**Growth and Sustainability
Regeneration and Culture
Planning and Building Control**

My Ref: 2022/0555 and 2023/ENQ/00340
Your Ref:
Date: 17 October 2023
Enquiries to: Helen Willows
Direct Dial: 01226 772642
E-Mail: helenwillows@barnsley.gov.uk

Description: Application under Section 96A of the Town and Country Planning Act 1990 as amended for a non-material amendment following a grant of planning permission

Address: The Mill, 10 Lower Castlereagh Street, Barnsley, S70 1AR

Drawing No.	Rev No.
EMS001 -009	A

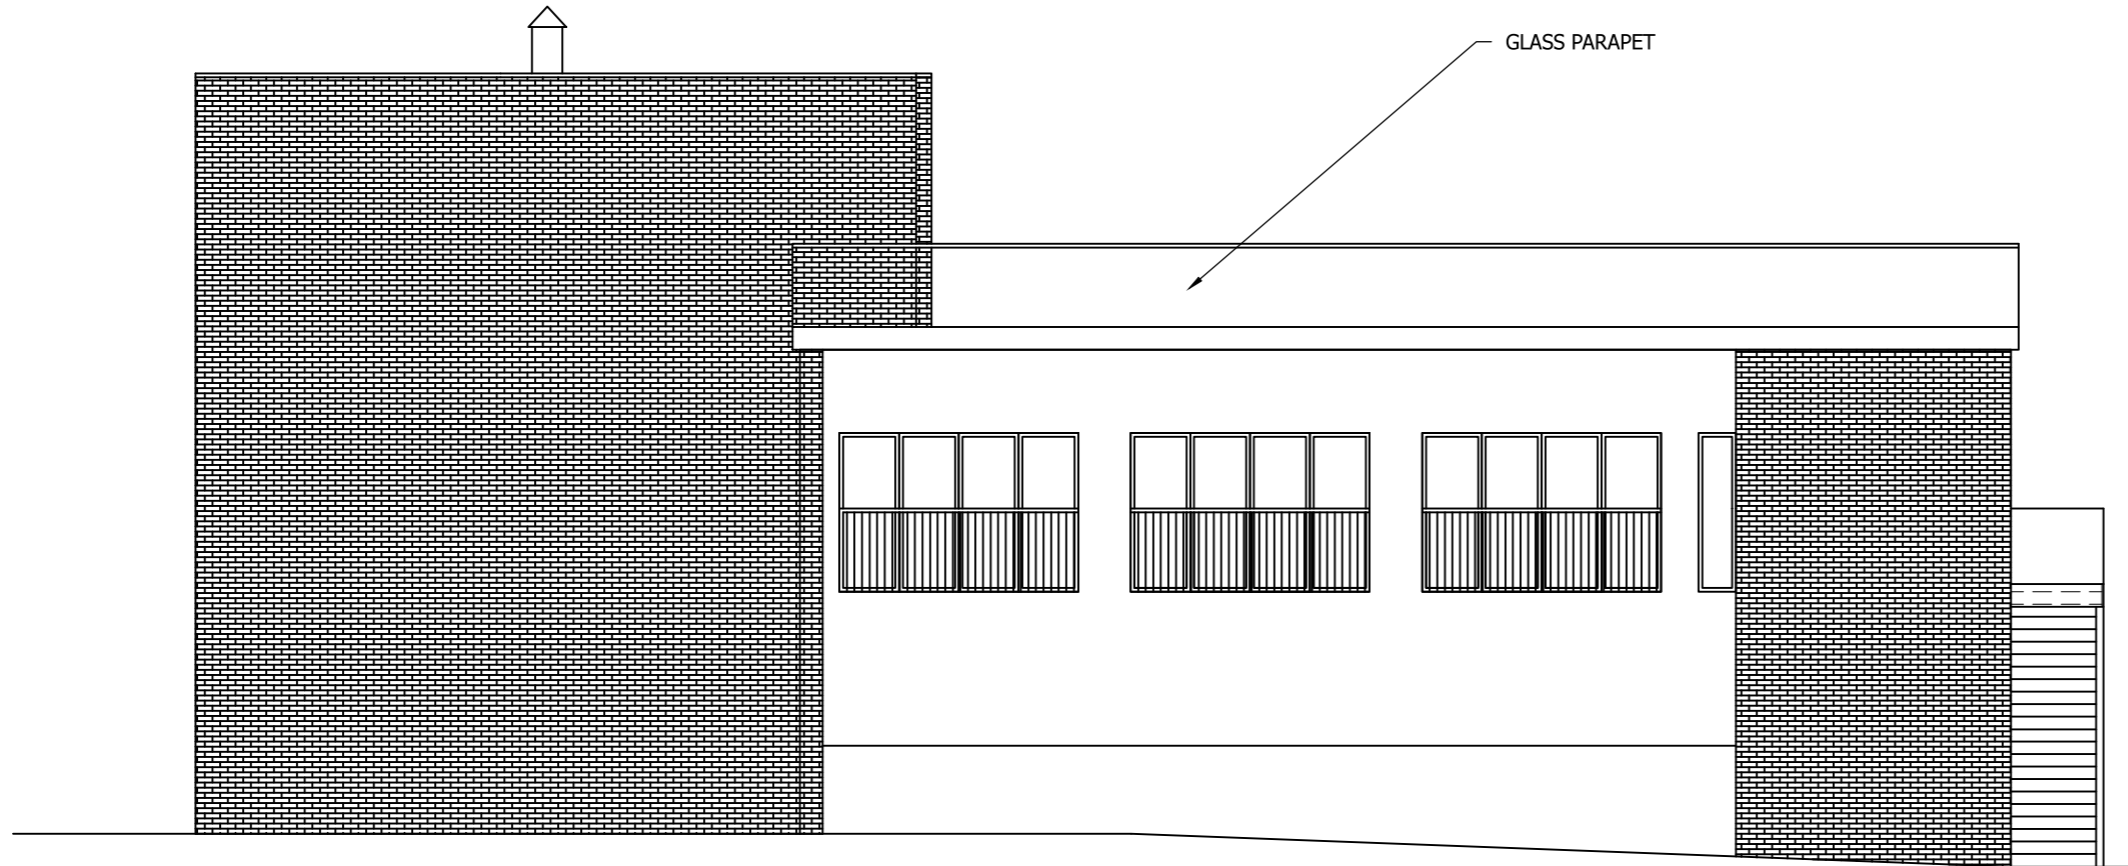
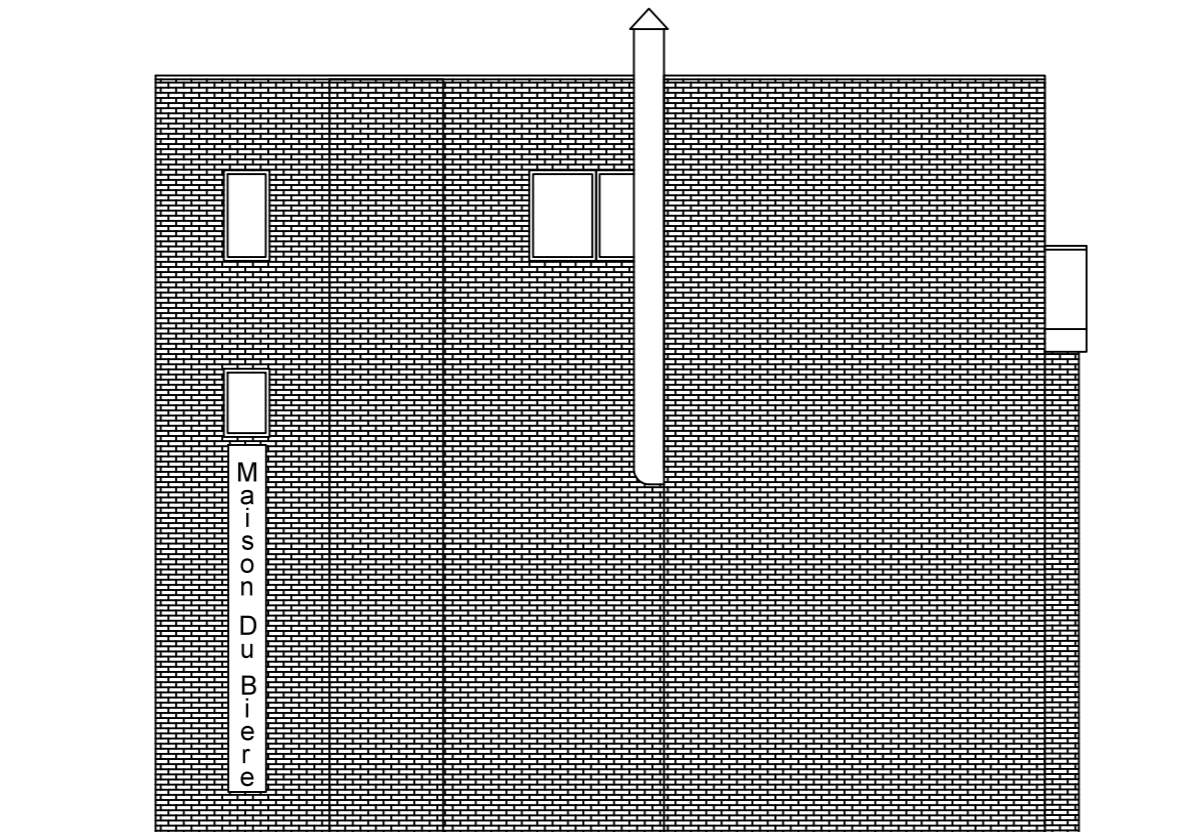
- Lift position changed. The stated reason being 'Moved away from listed building'.

The details submitted on plans (003B, 009B and 004B) are not acceptable because the proposed alteration would constitute a material change in design from the approved plans. The proposal is therefore not considered to be a non-material amendment.

Accordingly, I must confirm that the proposed non material amendment is not approved. You are advised to submit an application under Section 73 of the Act to vary the approved plans condition on the permitted scheme 2022/0555
